From: Andrew Wood
Sent: 11 April 2019 11:17
To: 'John Hall'
Cc: Planning.Responses
Subject: F/30/18/PL - Multispan polytunnels at Wicks Farm.

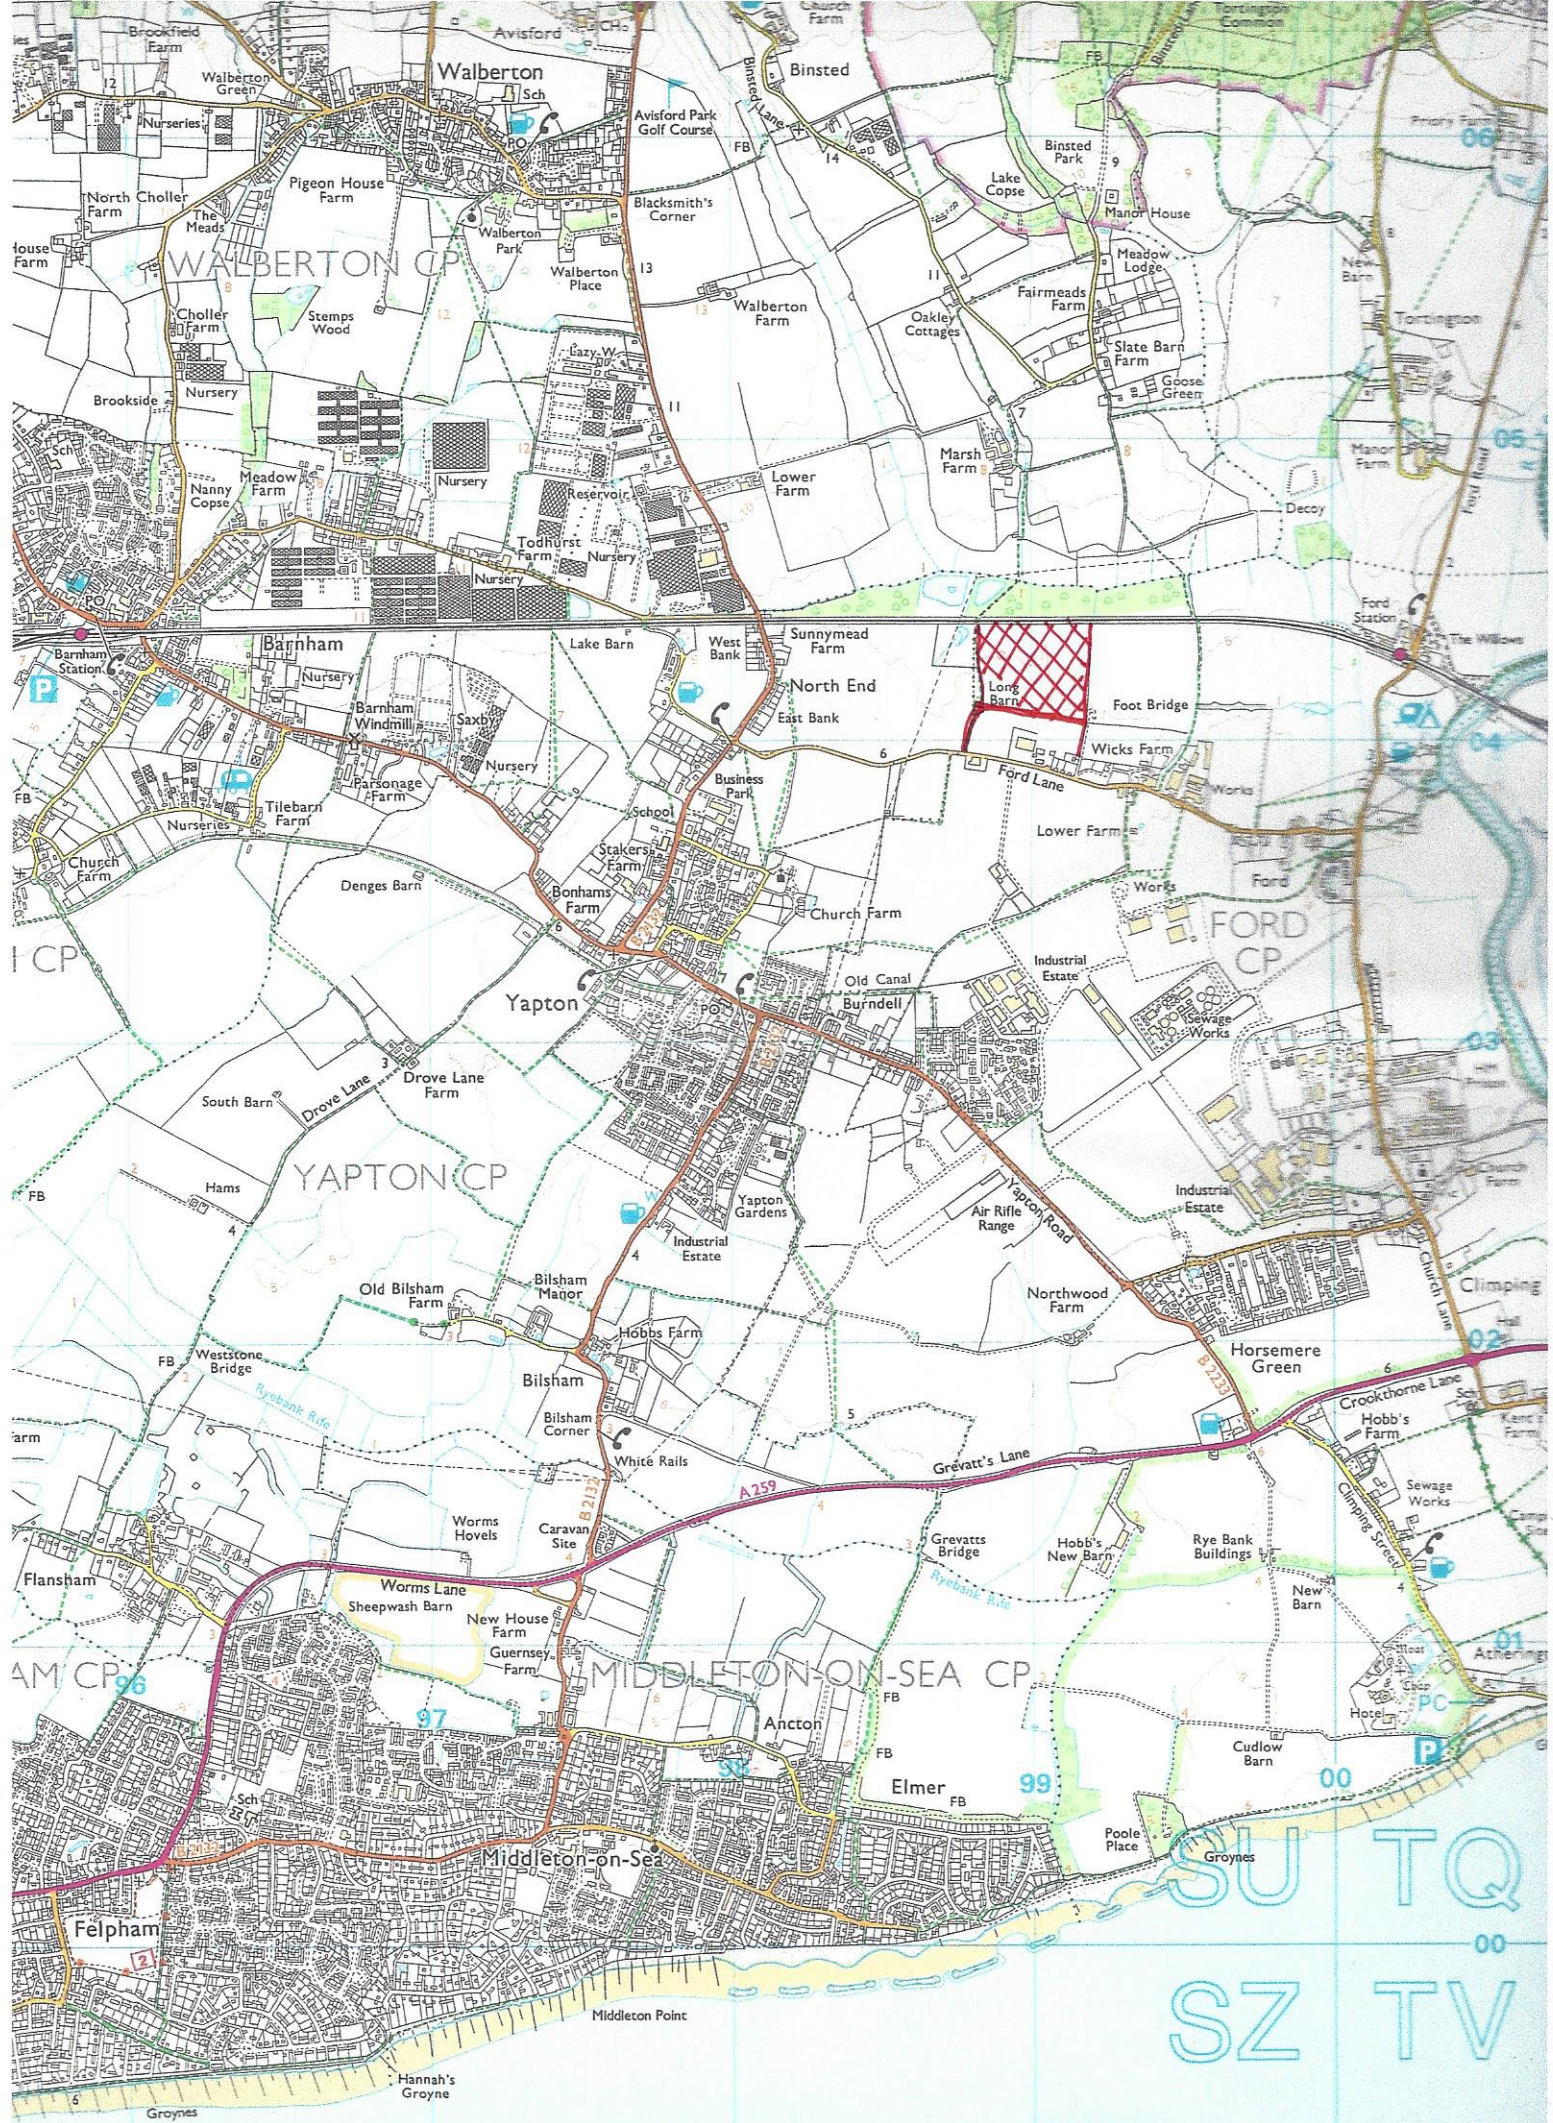
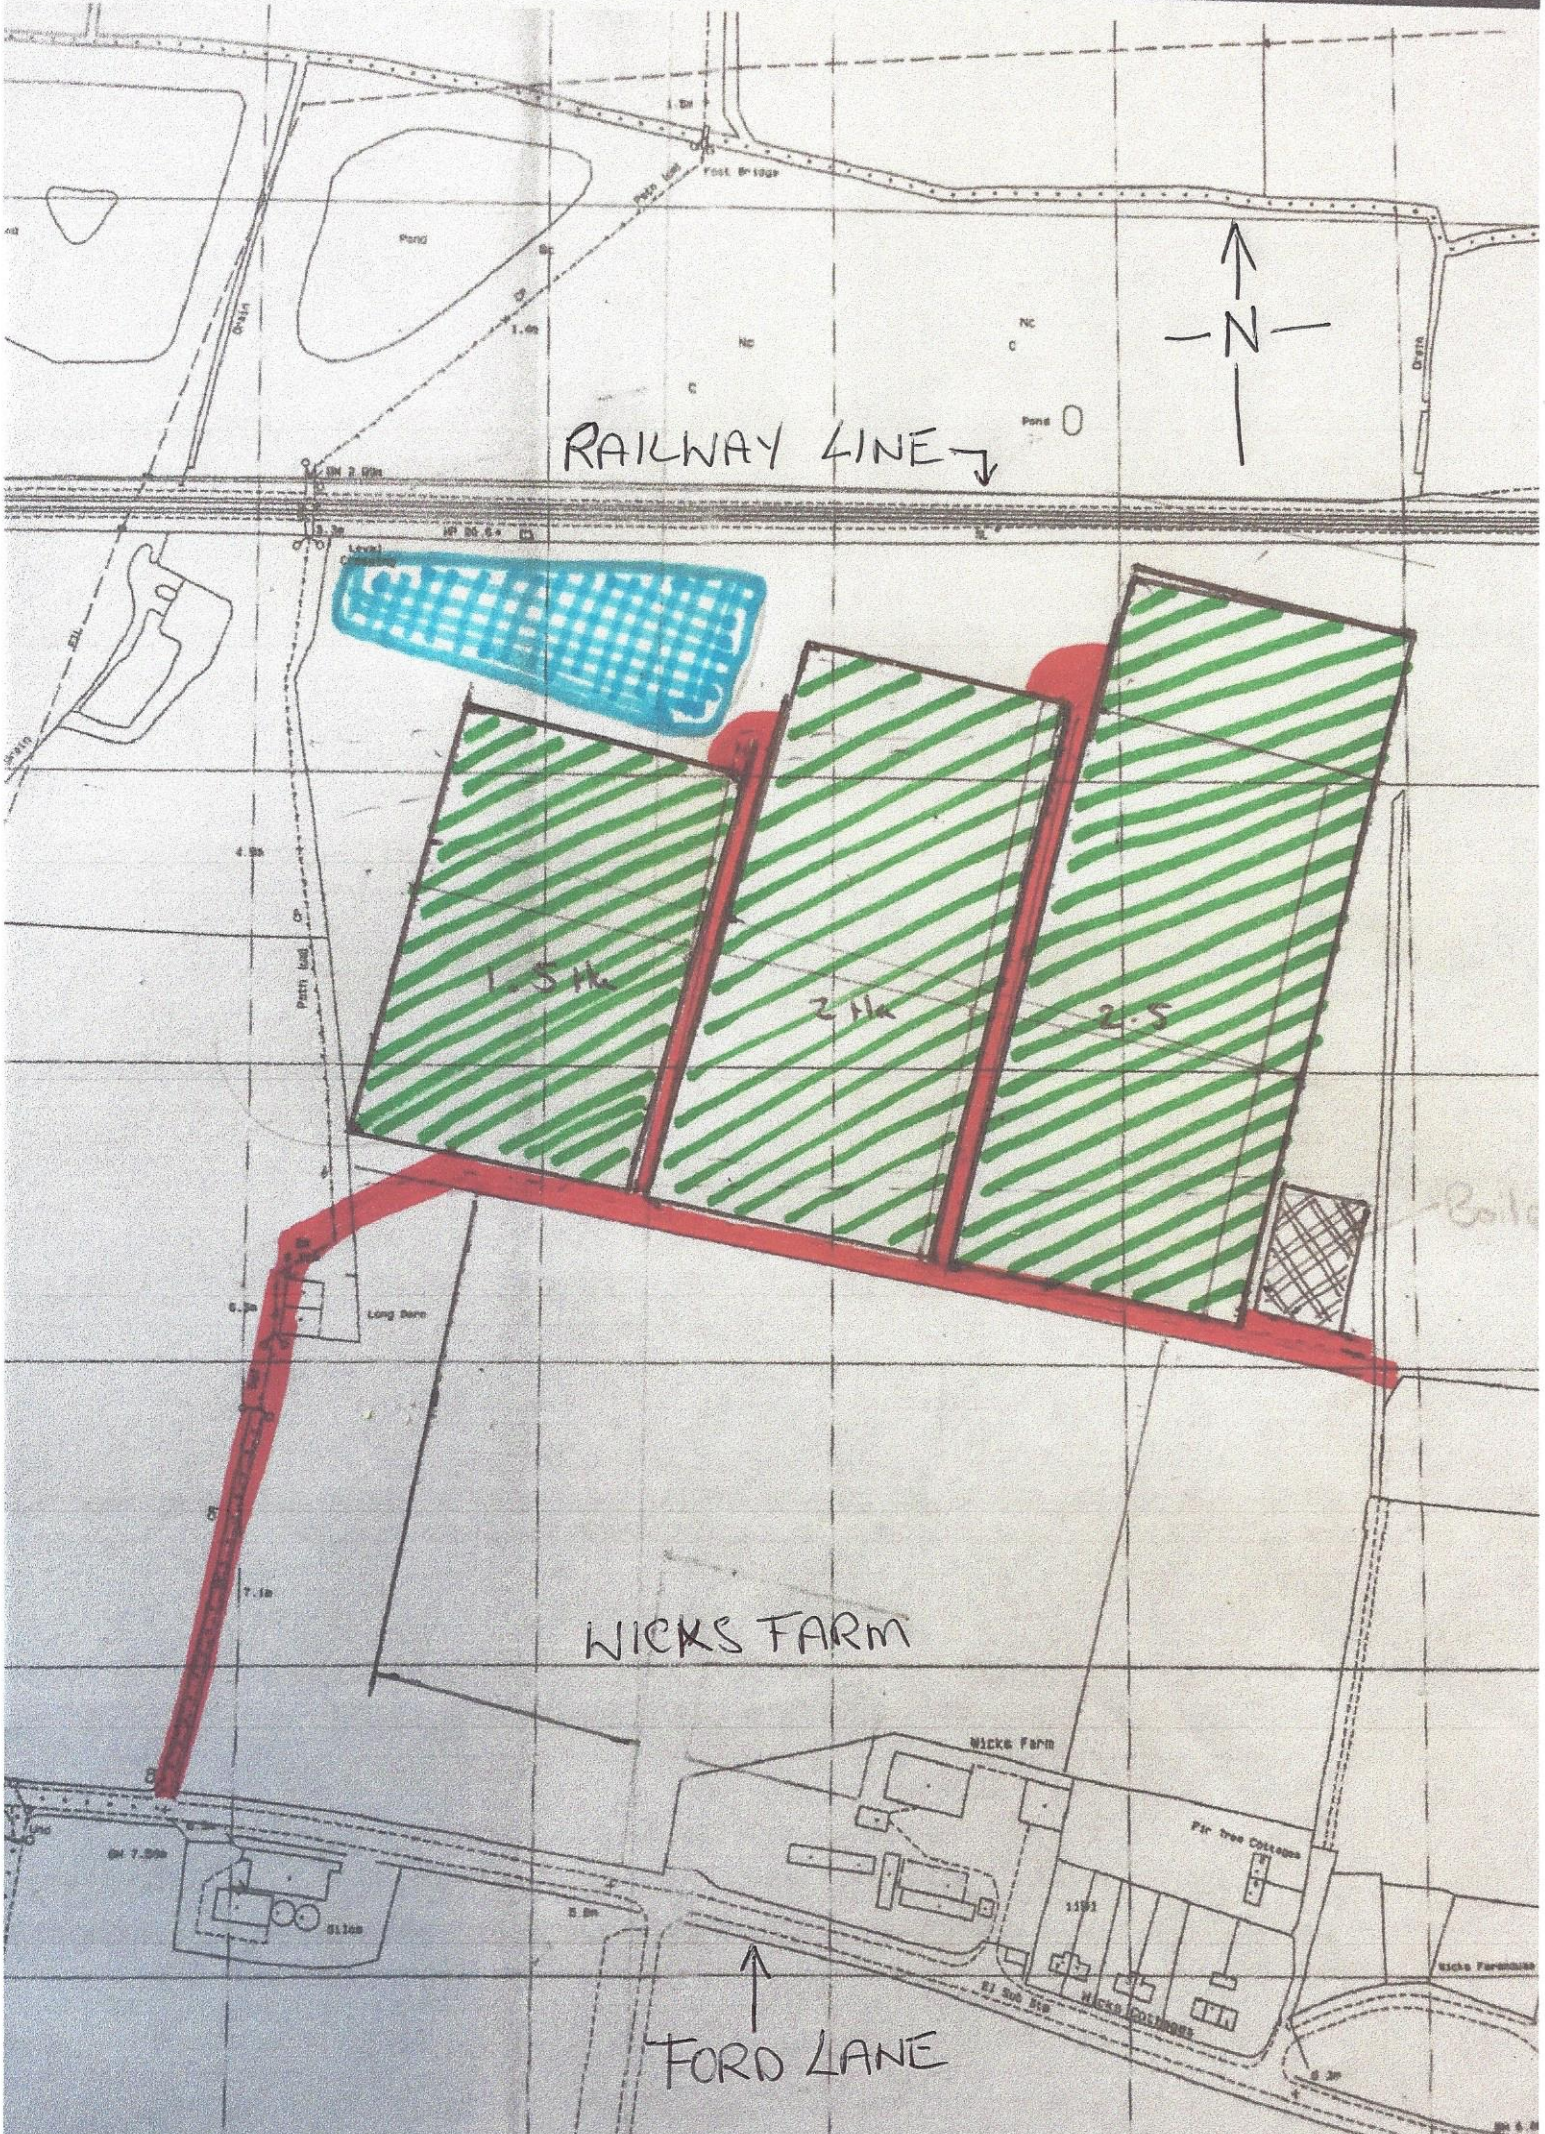
- 3) Can you amend the block plan to show where the parking for;
Light Goods Vehicles
Motor Cycles
Disability Spaces
Cycle Spaces
Mini bus spaces
- 4) Please confirm the final block plan include all lagoons/ drainage ponds as shown on the FRA appendices received on 11th February 2019.

Ancillary Building One

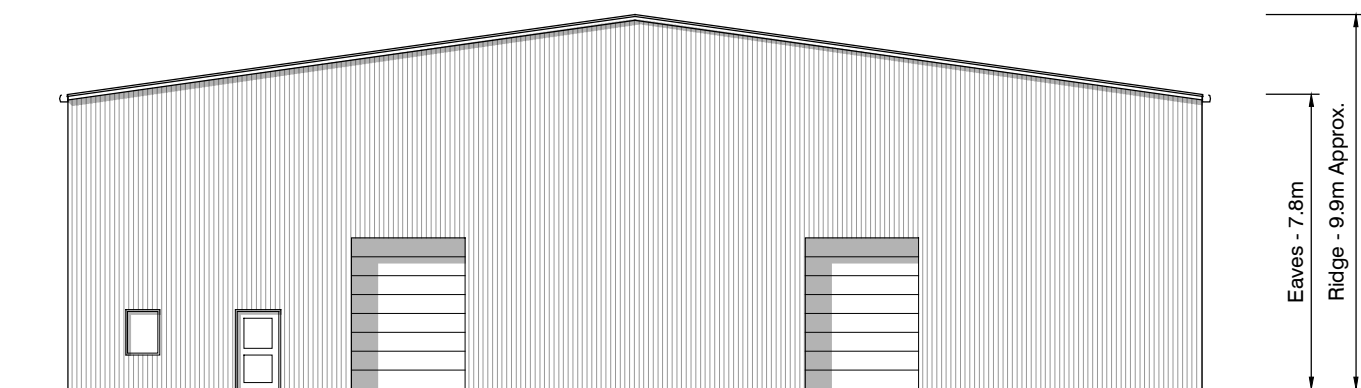
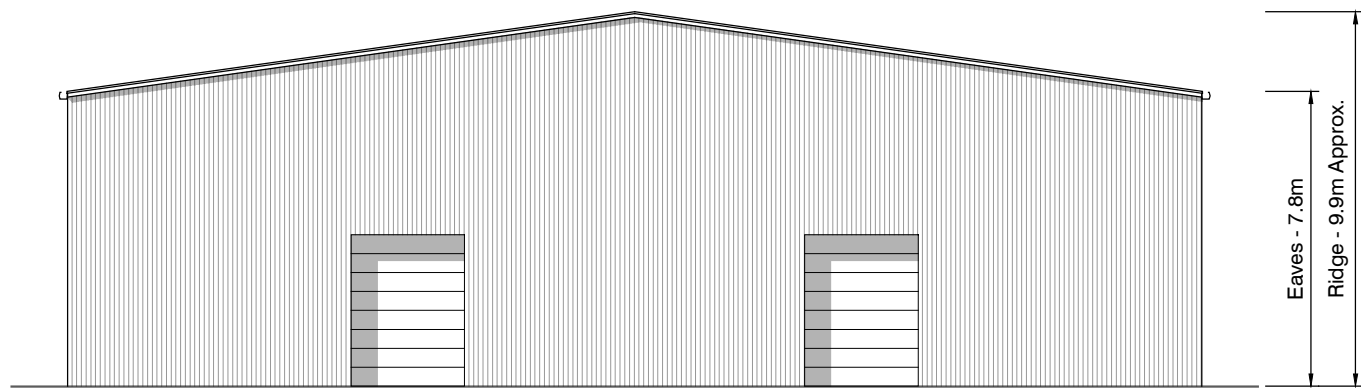
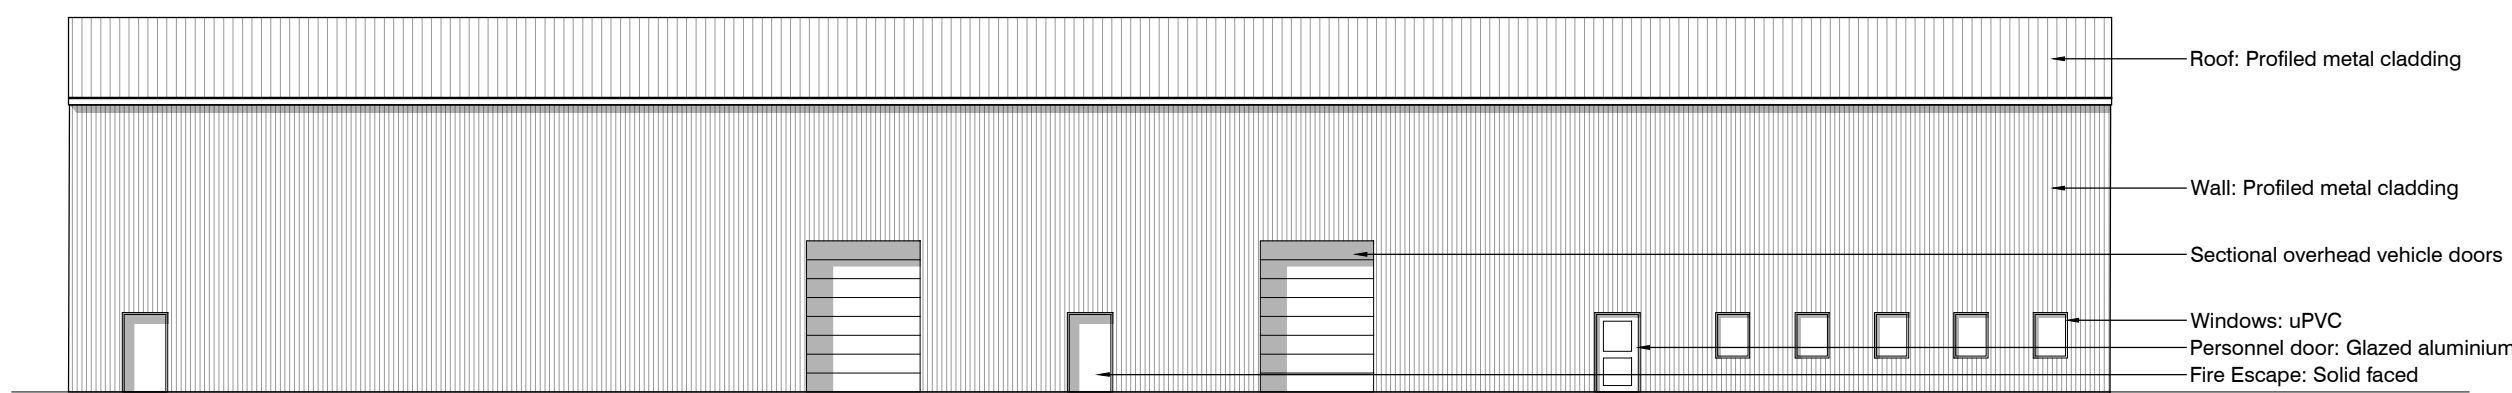
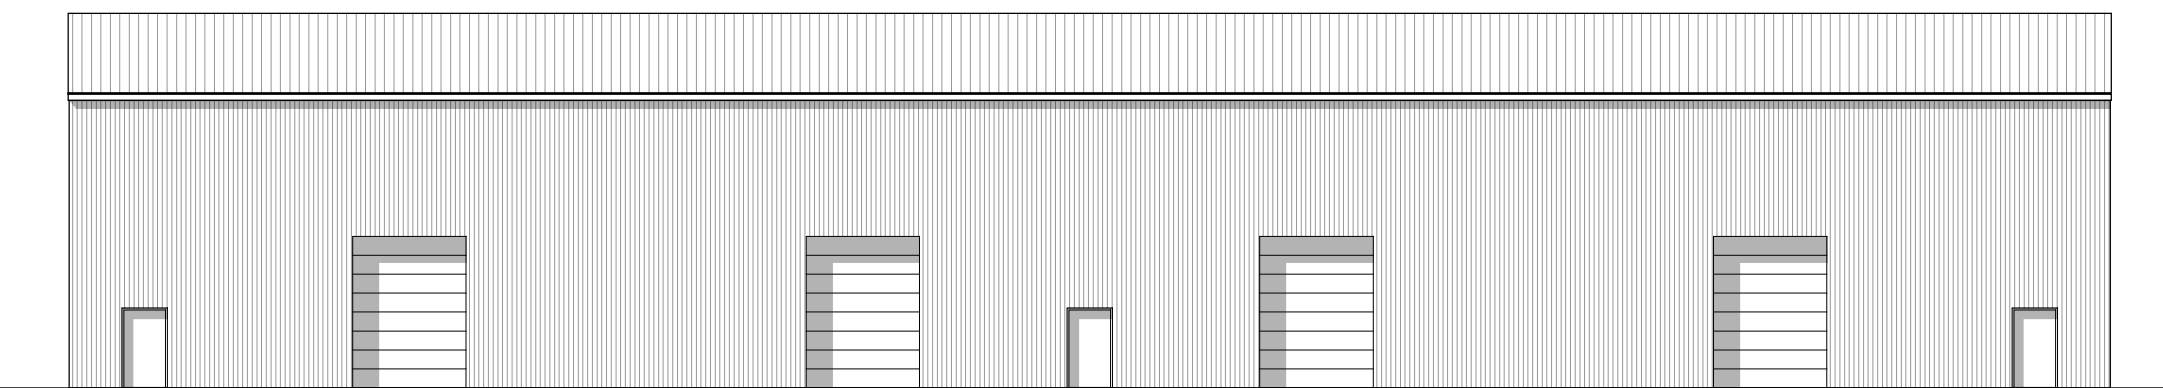
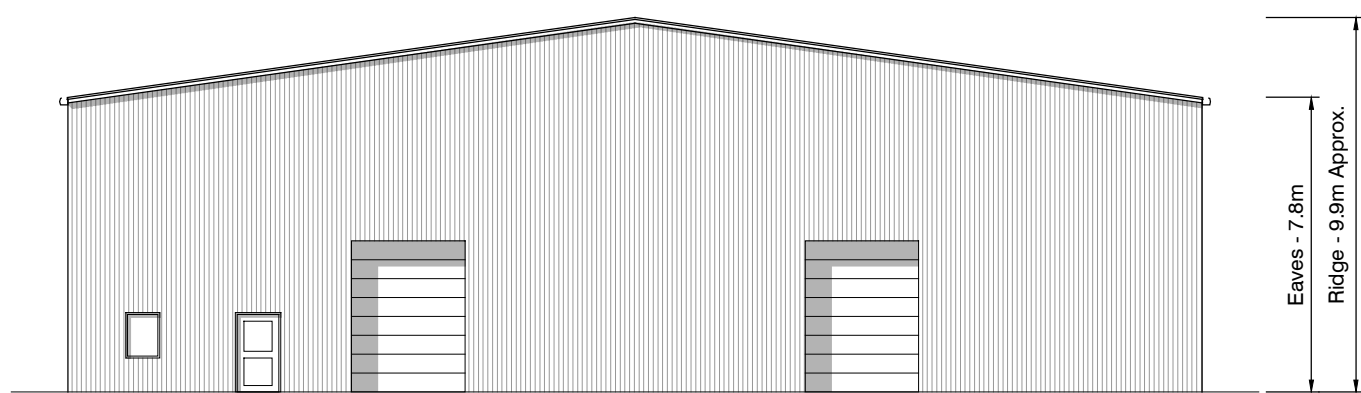
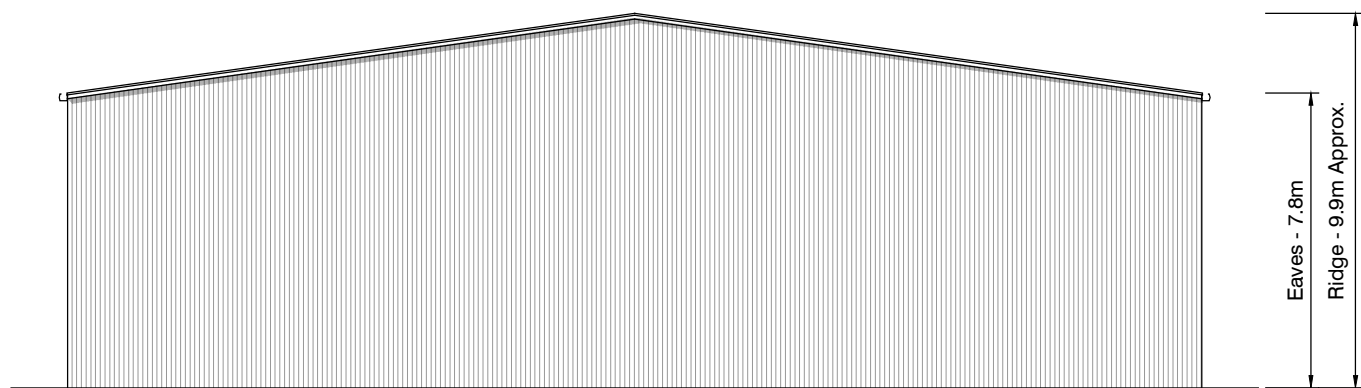
- 1) Can you clarify the description. It appears you are applying for two not three multispan polytunnels and associated works;
- 2) Can you provide elevation plans of the ancillary buildings.
